**From:** Hannah Riddle on behalf of Planning.Responses  
**Sent:** 26 April 2022 16:09  
**To:** Planning Scanning  
**Subject:** FW: Planning Re-Consultation on: Y/32/22/DOC

Engineers Comments Regarding Condition 8

**Application No:** Y/32/22/DOC  
**Registered:** 8th March 2022  
**Site Address:** 10 Acre Field Grevatts Lane West Yapton Bognor  
**Grid Reference:** 498000 101780  
**Category:** Discharge of Condi  
**Description of Works:** Approval of details reserved by condition imposed under ref W/4000394 (Y/102/18/PL) relating to Condition Nos 8 - surface water drainage and 10 - maintenance & management of surface water drainage system.

Hydrobrake chamber (type 1, simple control)  
Scale 1:20

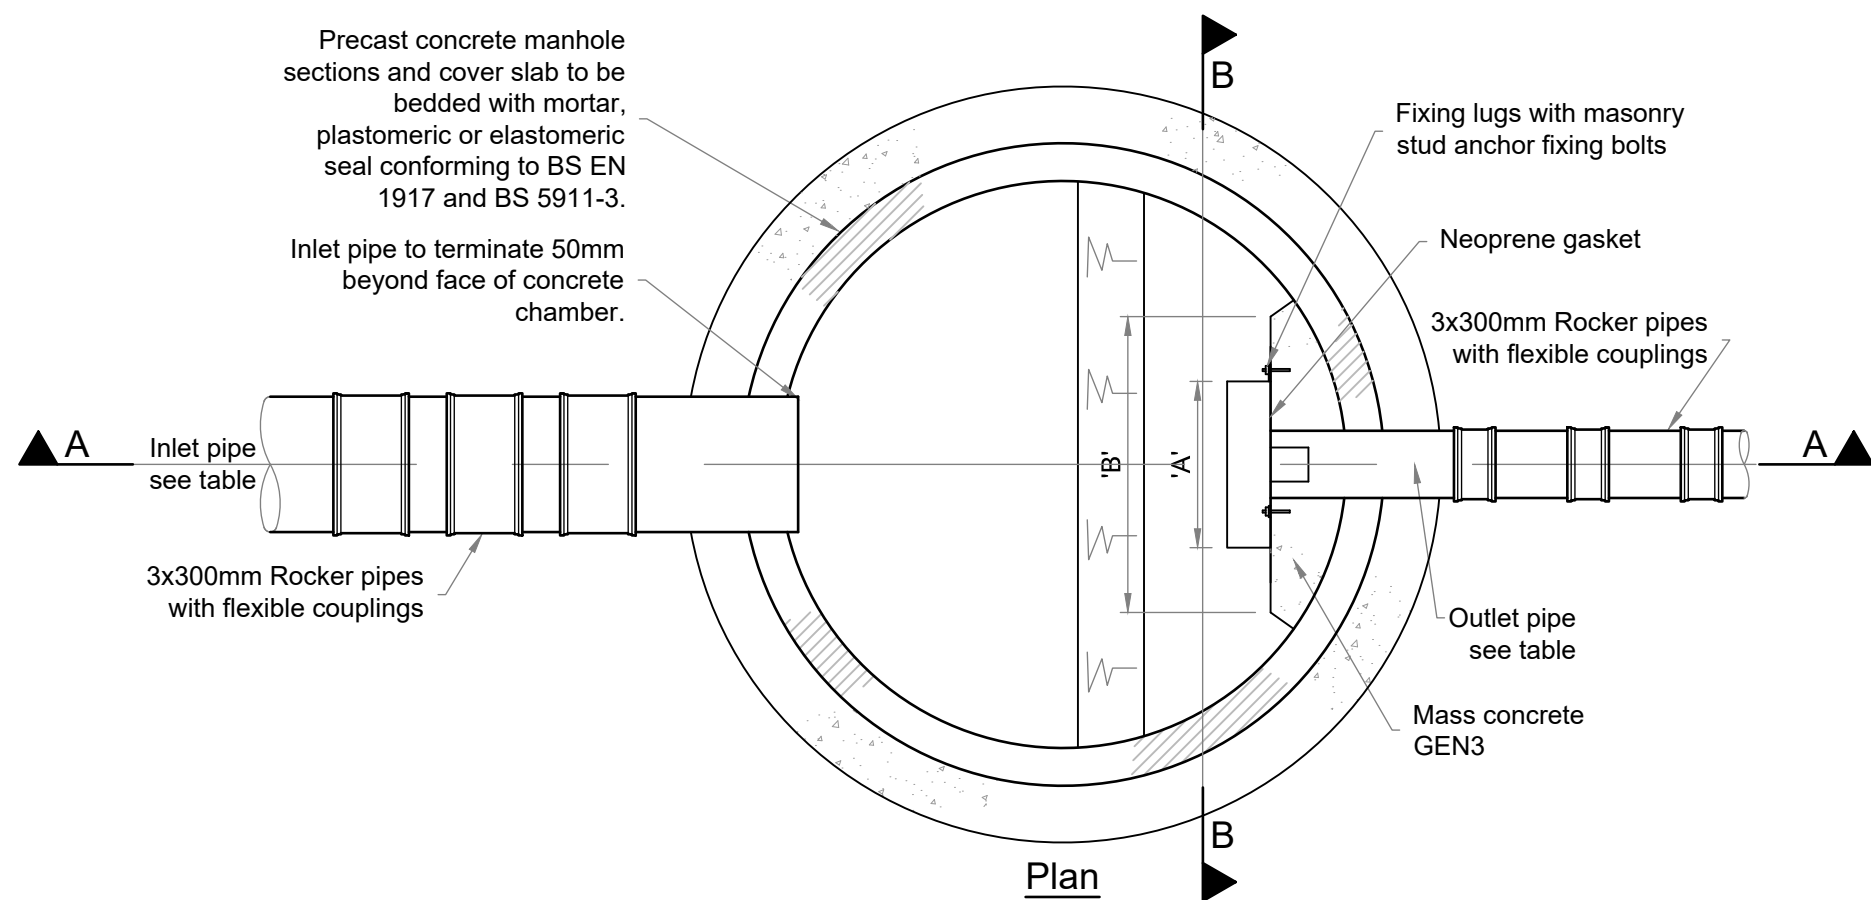
**5. Hydrobrake unit references should be included on layout plans.** Details have been added to updated drainage layout plan 13591-CRH-XX-XX-DR-C-5051 Revision P5. Okay, but please see comment above for more detailed calculations to evidence a compliant design. Hydrobrake reference on plans matches the calculations.

Project No.	Originator	Volume	Lvl/Loc	Type	Role	Number	Rev
13591	CRH	XX	XX	DR	C	5050	P6

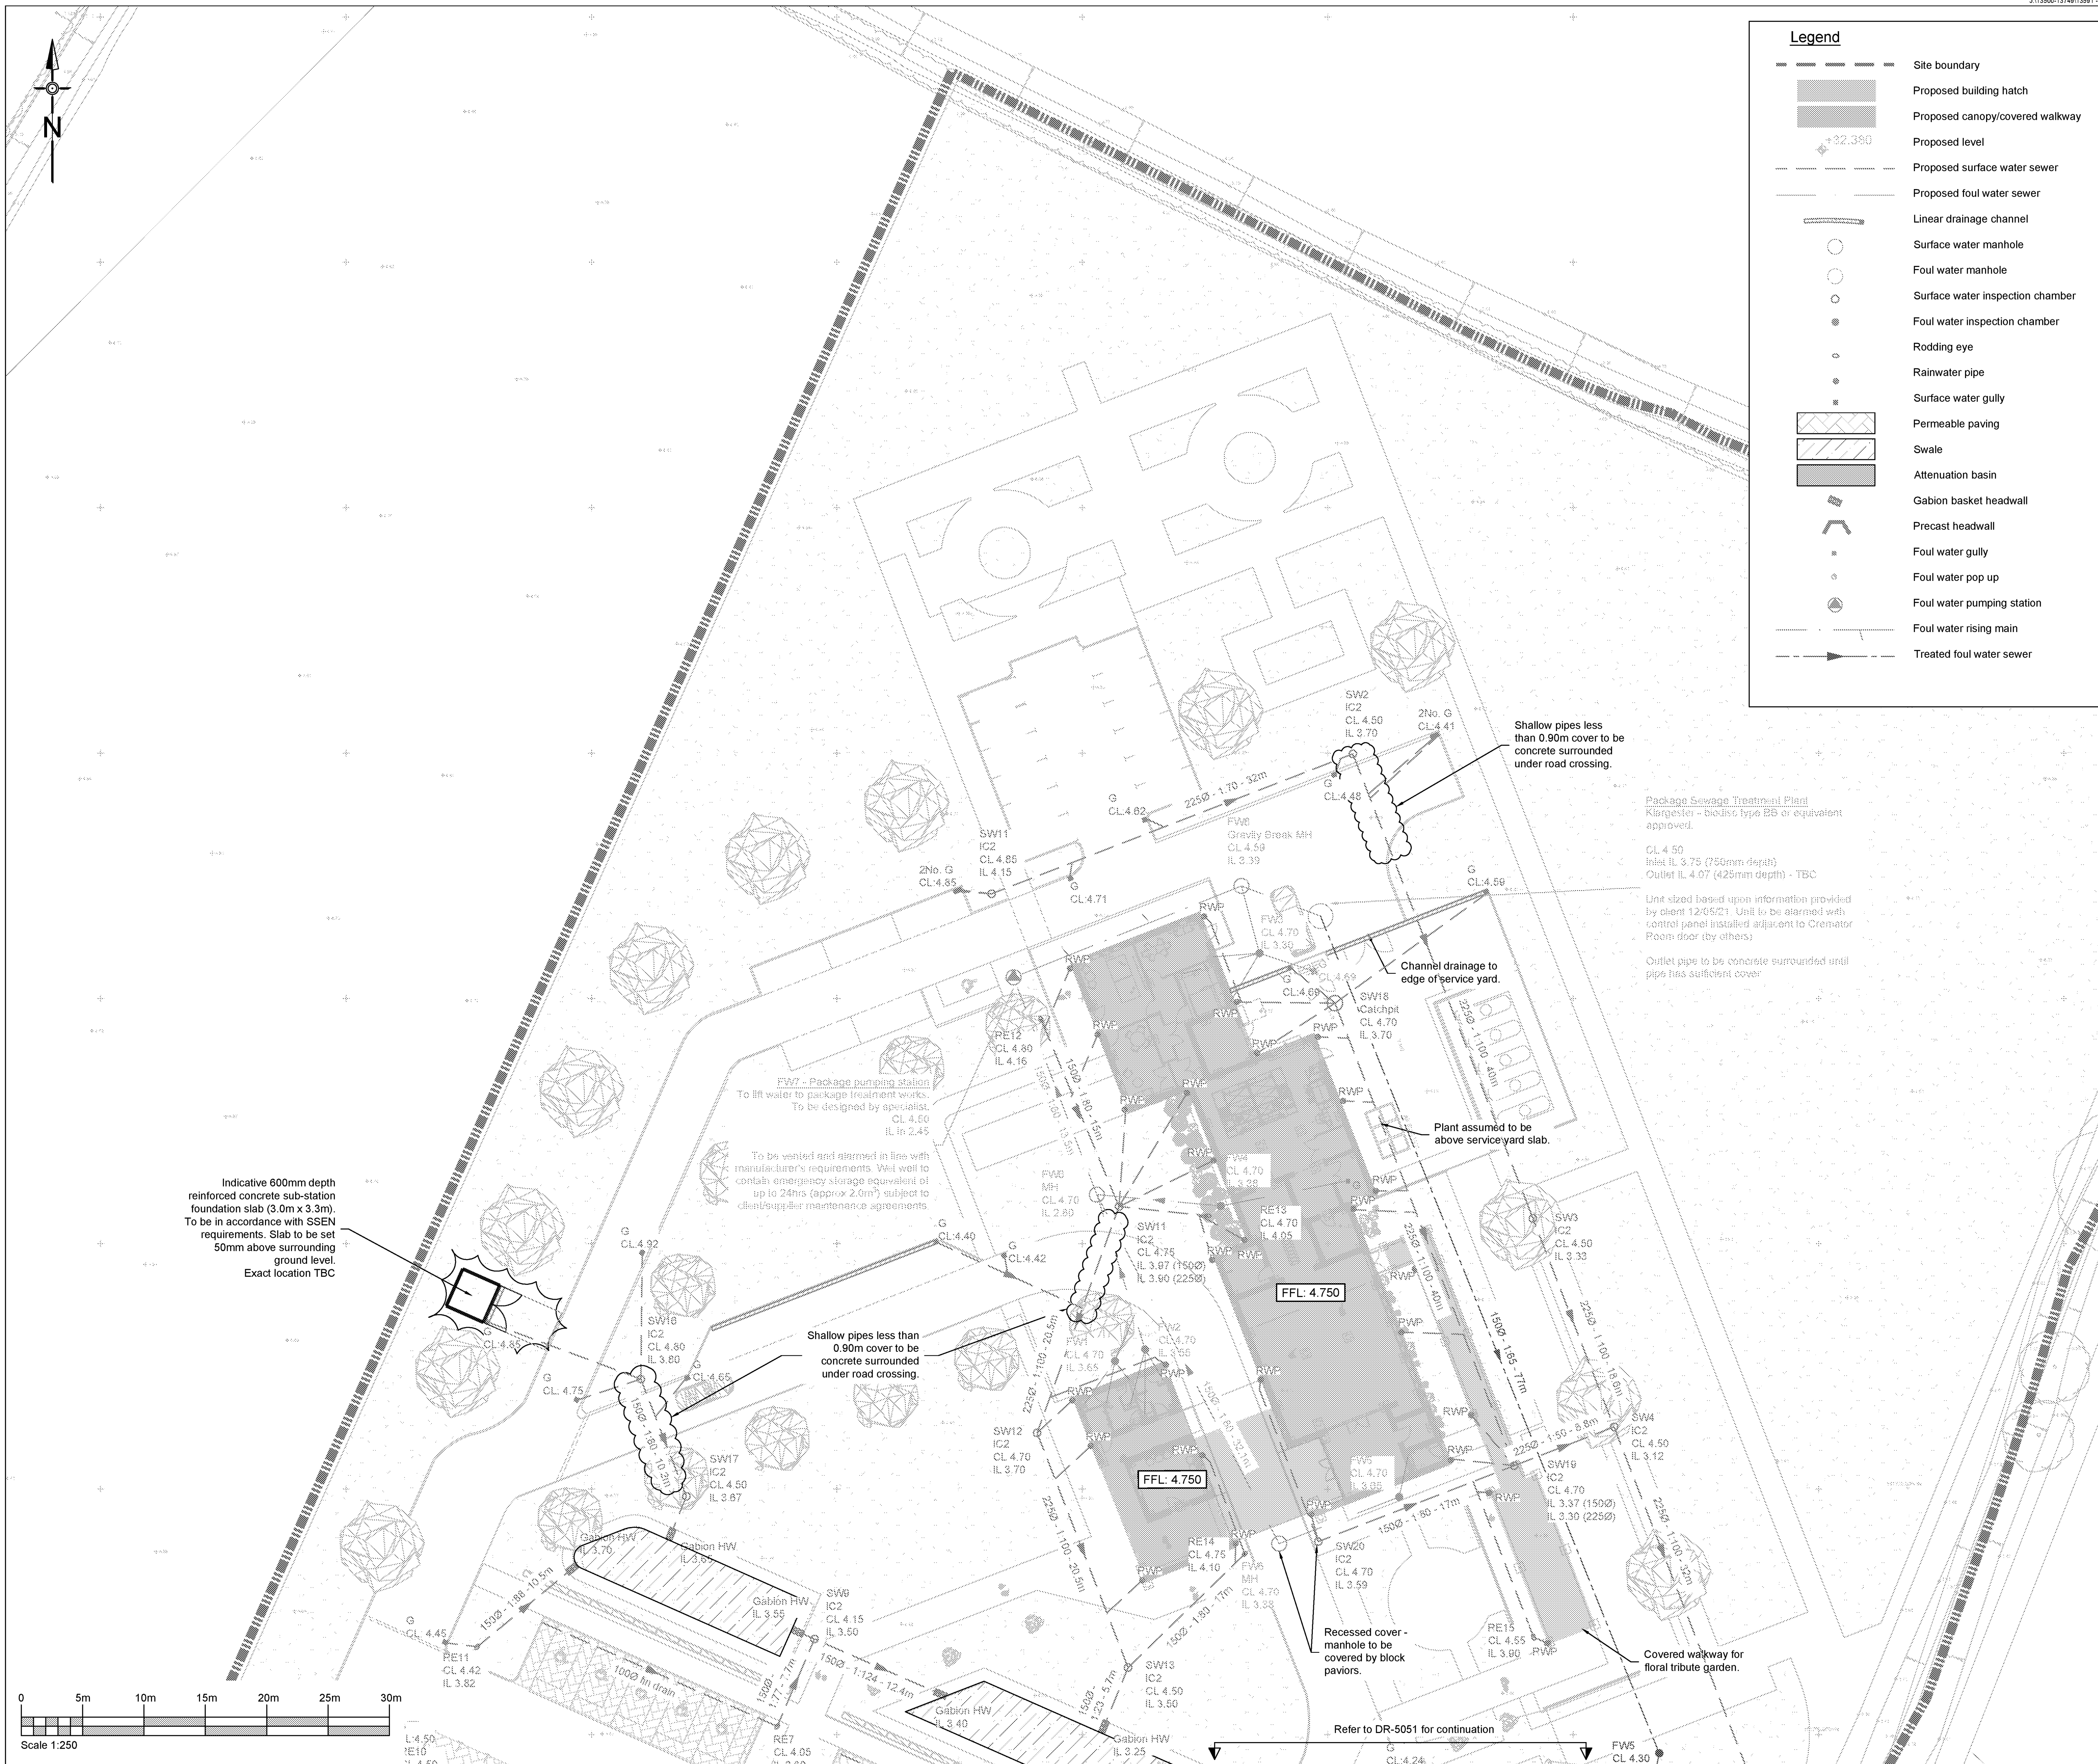
**4. Please label all pipes with diameter and fall.** Additional pipe labels have been added to drainage layout plans 13591-CRH-XX-XX-DR-C-5050 Revision P6 and 5051 Revision P5. Gradients for short (<5m) pipe lengths have not been shown. Pipe sizes, maximum grades and materials are to be as specified on drainage notes drawing 13591-CRH-XX-XX-DR-C-5300 Revision P1 previously provided. Okay.

**7. Gullies and channel drains should be labelled with cover levels.** Cover levels have been provided for proposed gullies on updated drainage layout plan 13591-CRH-XX-XX-DR-C-5050 Revision P6 and 5051 Revision P5. Channel drain cover levels will necessarily vary along the length and hence have not been provided. Exact levels will be

determined by contractor to suit the finished levels as shown on levels plan 13591-CRH-XX-XX-DR-C-5200 Revision P3. Levels should be provided on plan to ensure construction is carried out in accordance with proposals. Channel drain cover levels have been added to drawings DR-5050 and 5051 as requested. To be reviewed once an updated set of calculations is provided.

2. *Please supply a buffer plan to show that at least 3m is being provided between top of bank of watercourses and obstructing features, such as fences, buildings, and basins.* A suitable buffer has been provided between top of basin and edge of watercourse to allow for maintenance, as shown on drawing 13591-CRH-XX-XX-DR-C-5051 Revision P5. *Buffer not clearly shown, please show the buffer on a plan. A buffer has been shown on drawings DR-5050 and 5051 as requested. Okay.*

Project No.	Originator	Volume	Lvl/Loc	Type	Role	Number	Rev
13591	CRH	XX	XX	DR	C	5250	P1

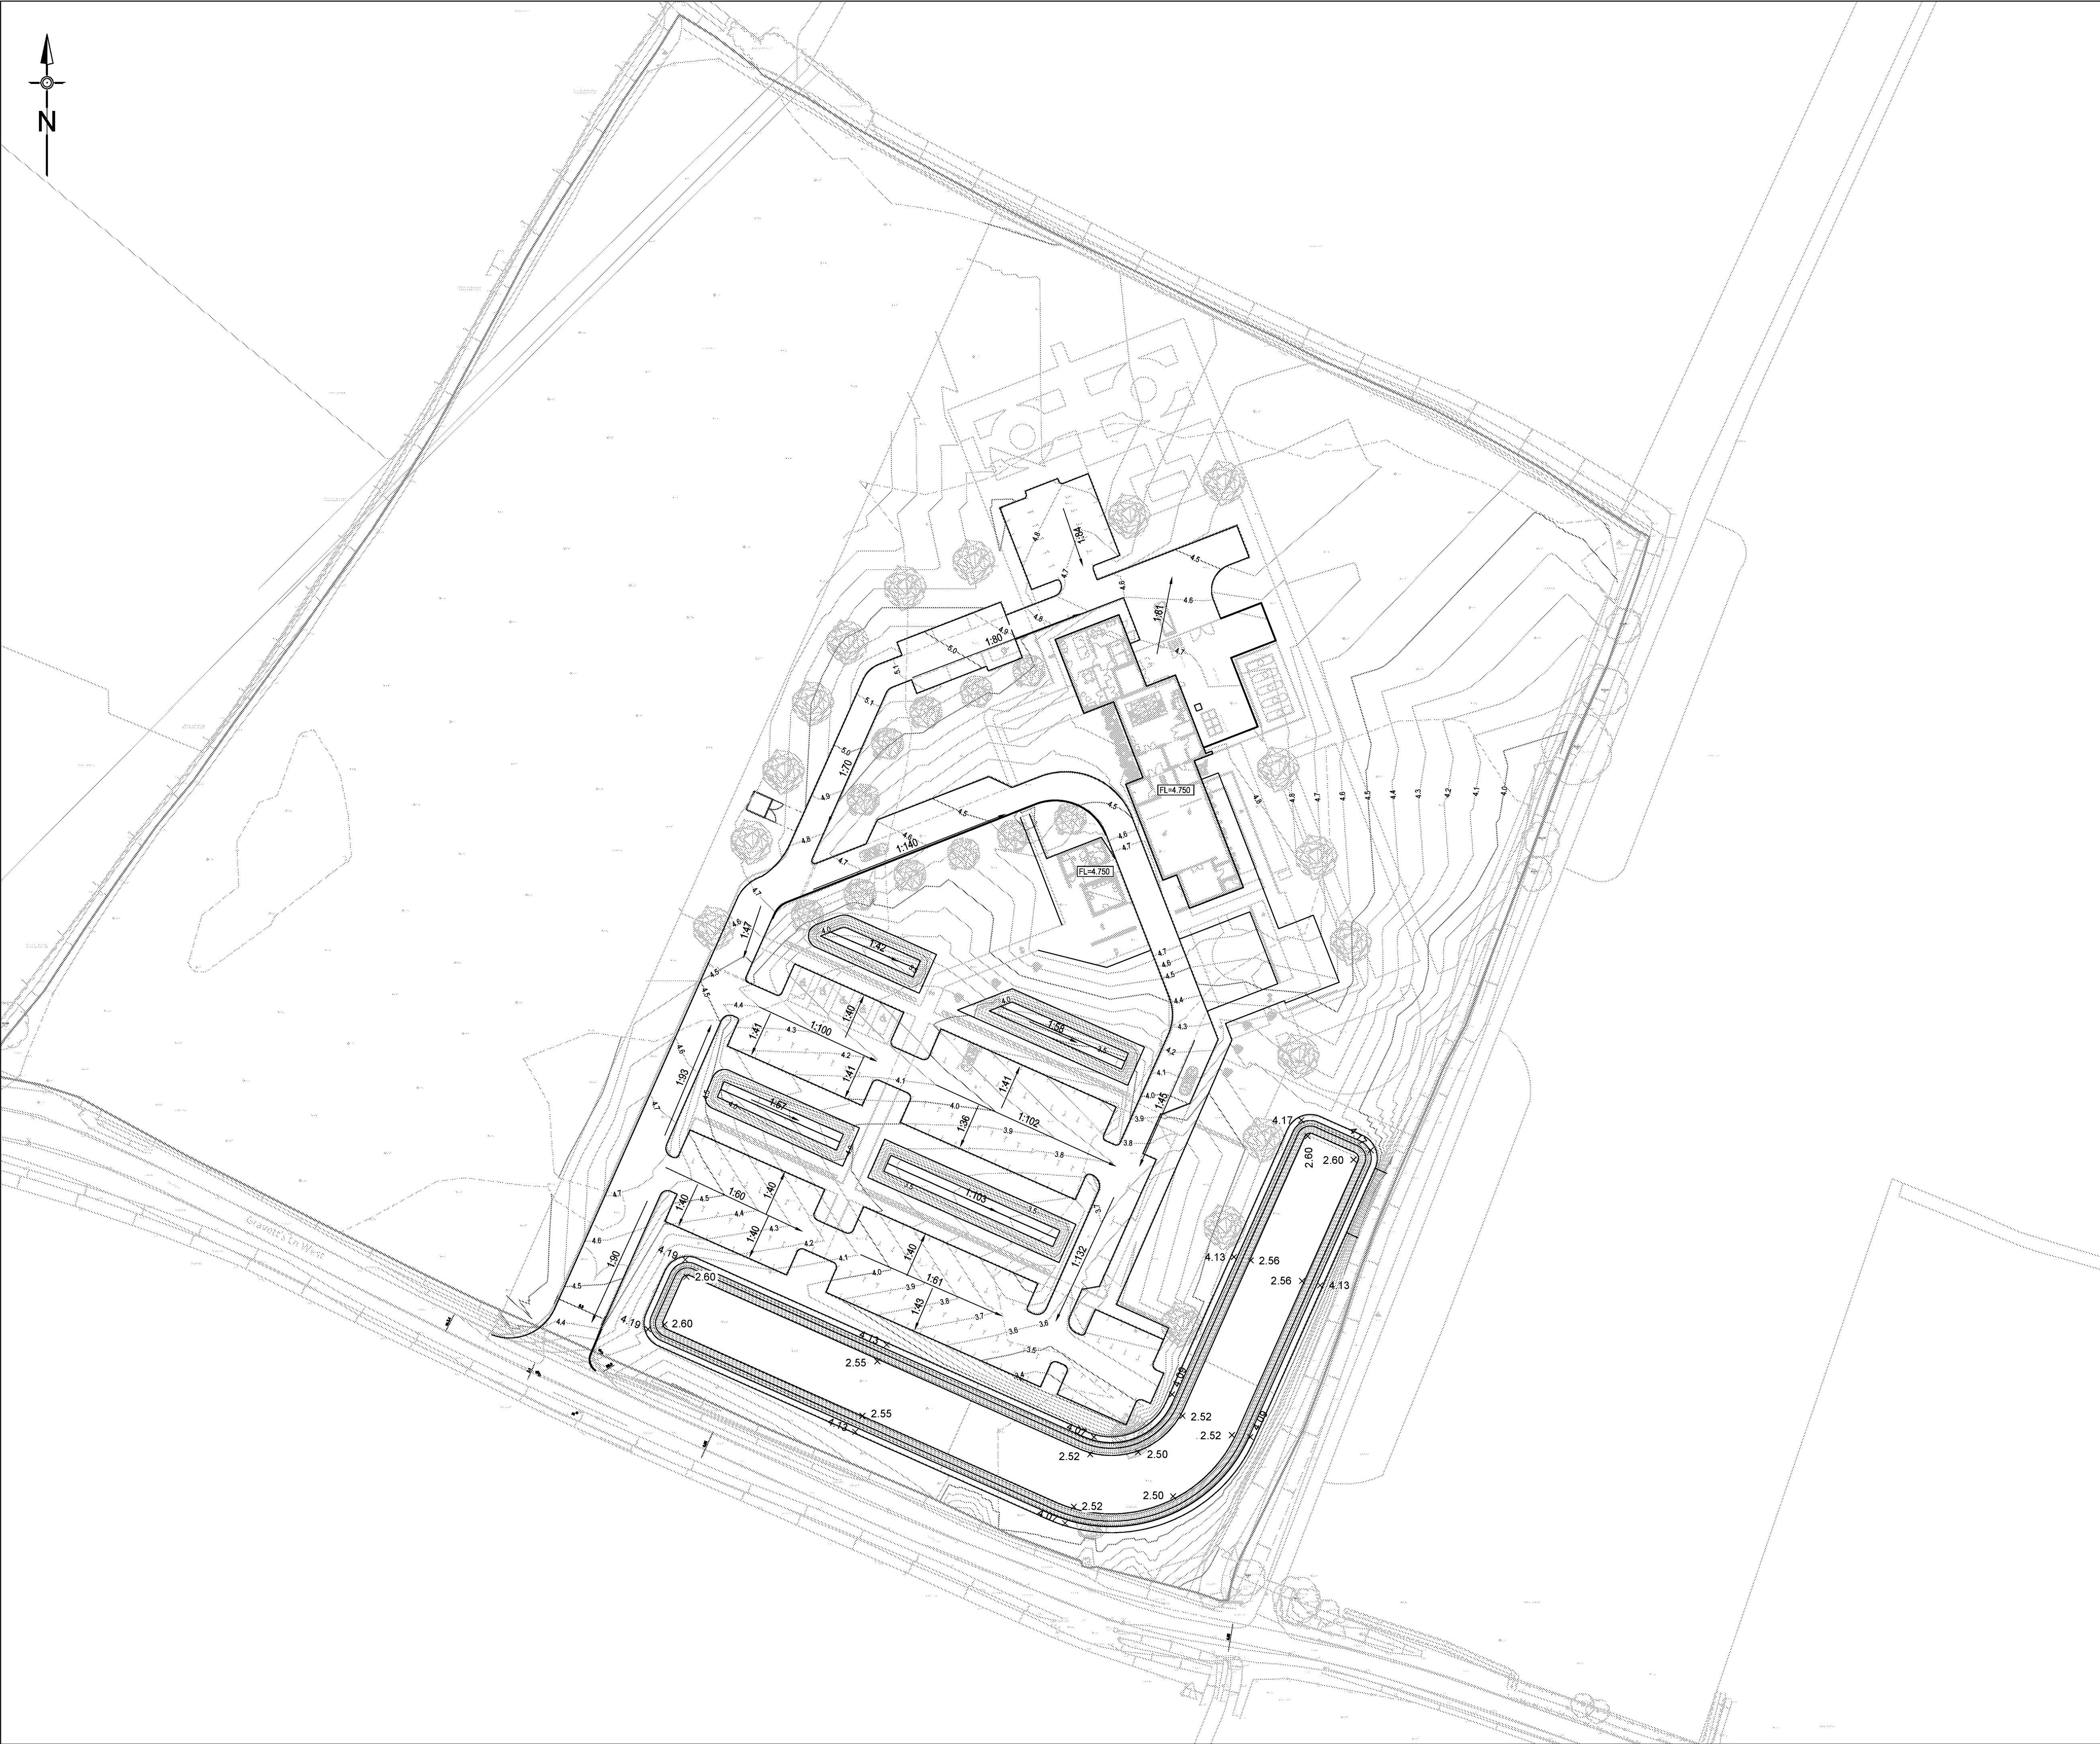
**3. Please supply an impermeable area catchment plan.** Please see enclosed impermeable area plan 13591-CRH-XX-XX-DR-C-5250 Revision P1. Okay. We have also included the additional detailed sub-catchment plan 13591-CRH-XX-XX-DR-C-5260-P1 to accompany the drainage calculations and provide absolute clarity as to which areas contribute to the model. To be further reviewed once points 1 and 2 are addressed.
